Rampion 2 Wind Farm

Applicant's Response to Historic England Deadline 1 Submission on Marine Archaeology

Document Reference: 8.63

Table 2-1 Applicant's Response to Historic England's Written Representation (marine archaeology issues) [REP1-055]

Figure 1-3 Valleys and channels of georchaological potential

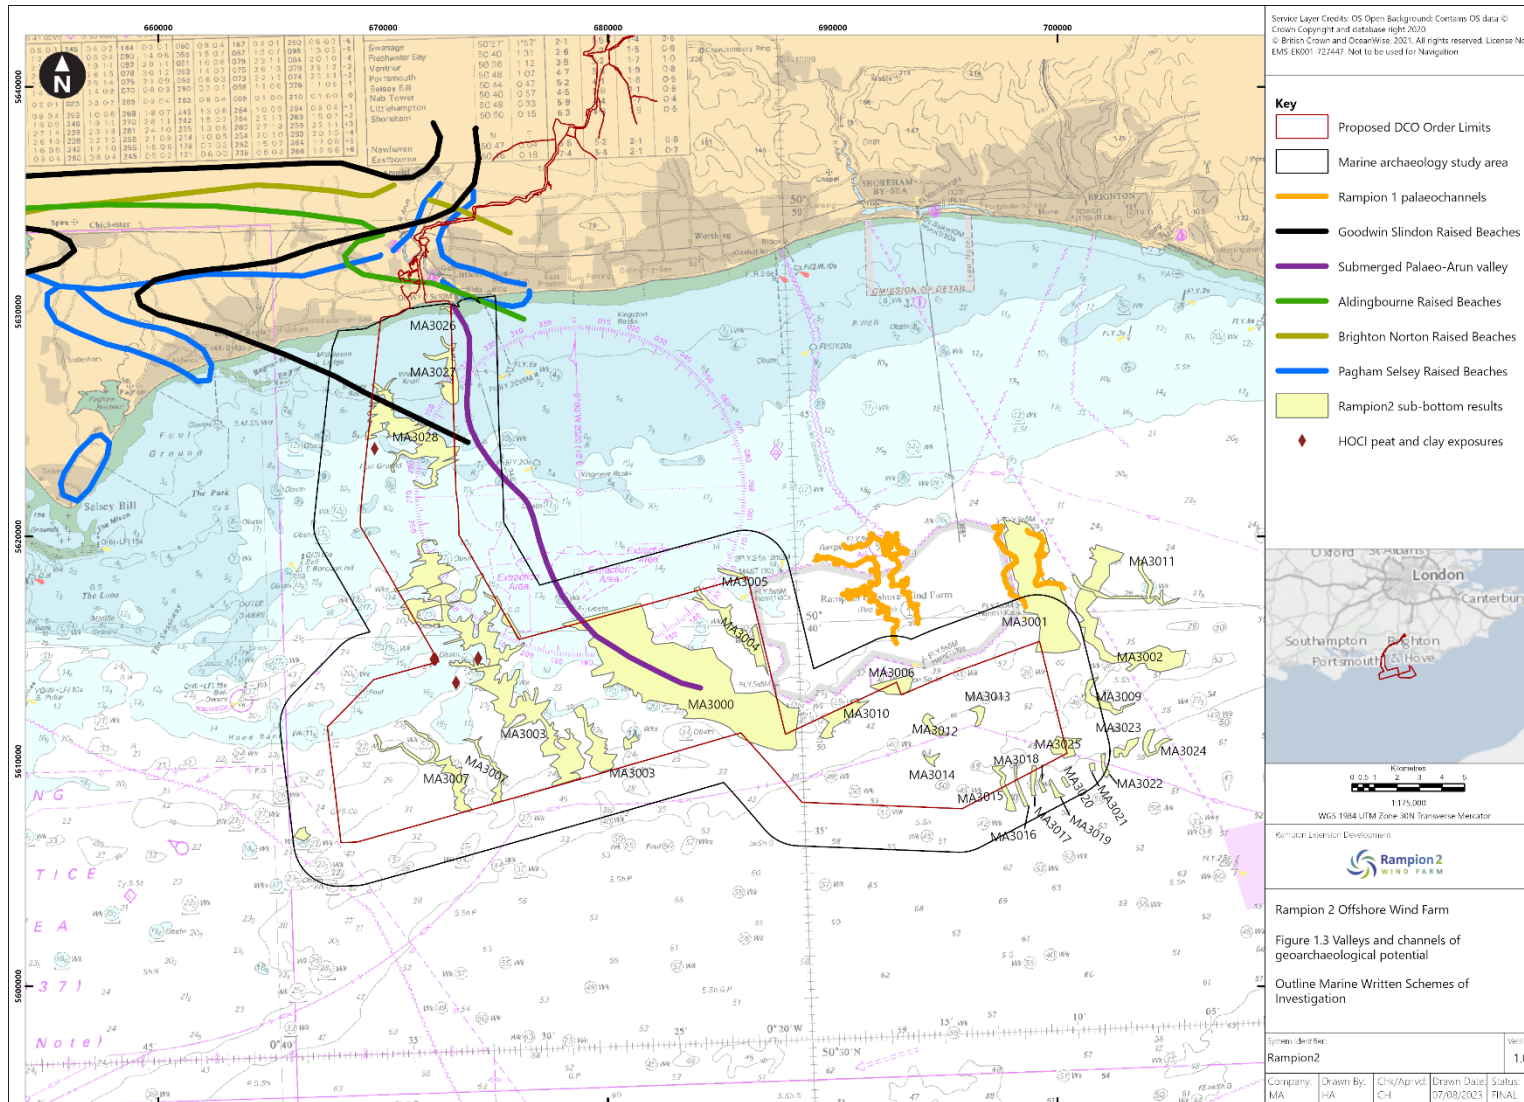
5.8	<p>5.8 We note that paragraph 16.6.36 explains how a prehistoric channel system (Ref: MA3001) of possible archaeological interest identified through the studies conducted for the Rampion 1 development, extends into the Rampion 2 survey area. However, Table 16-14 is described as a “preliminary deposit model” but doesn’t appear to include detail as alluded to</p>	<p>Section 16.6 within Chapter 16: Marine archaeology, Volume 2, [APP-057] (updated at Deadline 3) summarises the baseline assessment. Full details are included in Appendix 16.1: Marine archaeological technical report, Volume 4, [APP-162] (updated at Deadline 3). The preliminary deposit model has taken into account all datasets and the locations</p>

Ref	Written Representation Comment	Applicant's Response
	in paragraph 16.6.41 regarding peat exposures, which could be of significant geo-archaeological interest.	where peat or clay were noted during a seabed habitat mapping survey are included in Figure 16-4, Chapter 16: Marine Archaeology – Figures, Volume 3 [APP-096] . The outline deposit model will be further refined following a staged geoarchaeological assessment as per the commitments and obligations detailed in the Outline Marine Written Schemes of Investigation, [APP-235] (updated at Deadline 3).
